**KIRKLEES METROPOLITAN COUNCIL  
INVESTMENT & REGENERATION SERVICE**

| Reference No:         | <b>2023/62/93348/W</b>                                                                             |
| Site Address:         | 22, Goldcrest Court, Netherton, Huddersfield, HD4 7LN                                              |
| Description:          | Erection of single and two storey extension to dwelling and single storey extension to outbuilding |

Proposed First Floor Plan

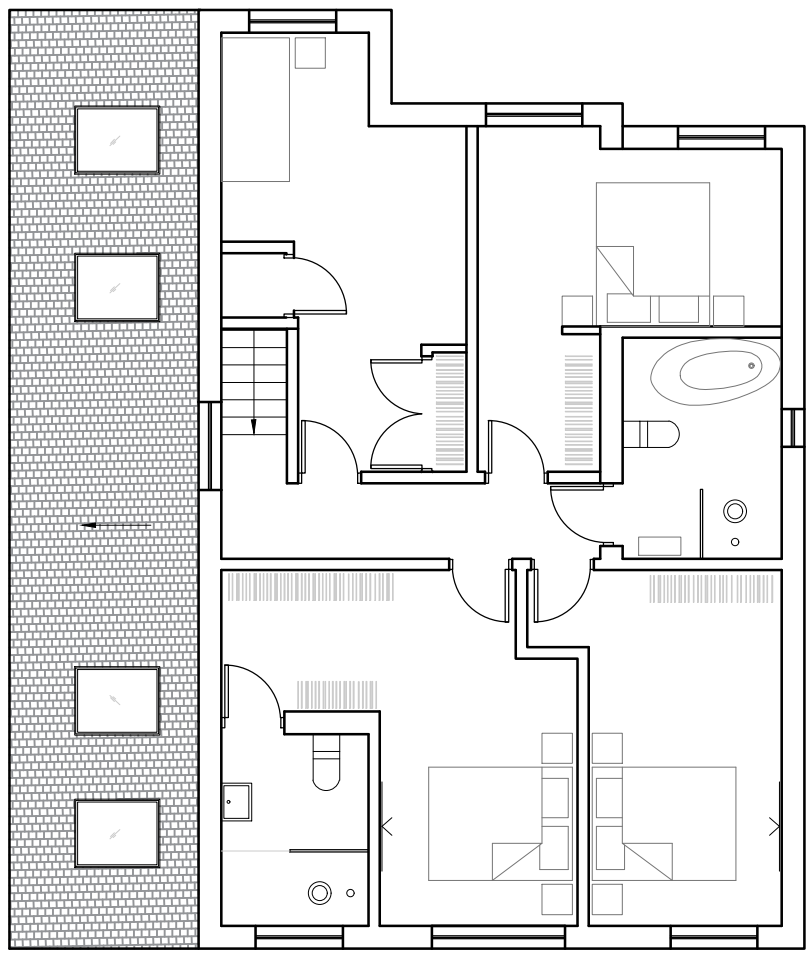
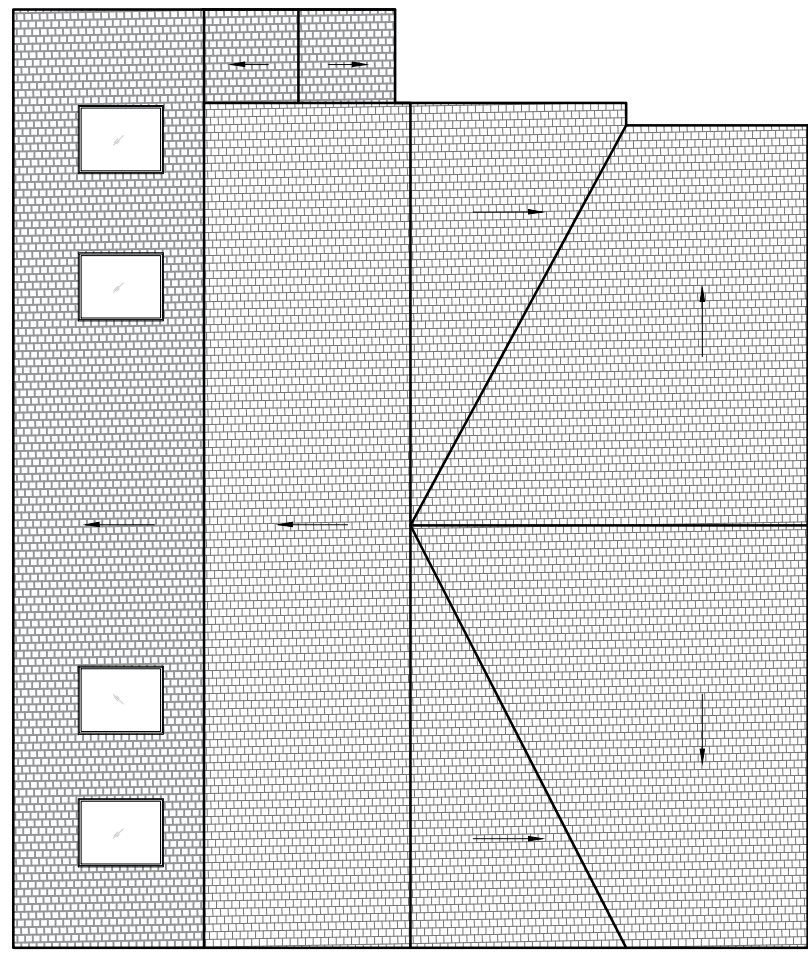
Firstly, the proposed front extension is two-storey in height and is not considered to be of a small or subservient design to the original building. It would project forward of the principal elevation of the host dwelling by 1.2 metres and is not considered to be sufficiently set down, with the ridge height of the front extension to meet the eaves height of the host roof.

The design of the proposed single storey side extension is contrary to the recommendations as set out within the House Extensions and Alterations SPD. Whilst the width of the proposed single storey side extension would not exceed two thirds of the width of the original house or the height exceed 4 metres, the extension would project forward of the principal elevation of the host dwelling by 1.2 metres.

The design of the proposed two-storey side extension to 22 Goldcrest Court is contrary to the design principles of the House Extensions and Alterations SPD as set out above. The two-storey side extension would not appear as a subservient addition to the host property, presenting an undue extent of additional bulk/massing to the front and side of the dwellinghouse.

The projection of the side extension would abut the shared boundary with No. 24 Goldcrest Court to the rear and the majority of the built form that makes up the side extension would be separated from this shared boundary by less than one metre. In addition, the ridge height of the extension would be set down from the ridge height of the host dwelling by only 0.2 metres and would be set back only 0.3 metres from the principal elevation of the host property.

The proposed two-storey side extension would introduce a solid blank elevation which abuts the shared boundary with No. 24 to the rear and the majority of the built form that makes up this side extension would be separated from this shared boundary by less than one metre. As a result of this, it is considered that the proposed two-storey side extension introduces an undue extent of overbearing upon the occupiers of this neighbouring property and would be unduly oppressive.
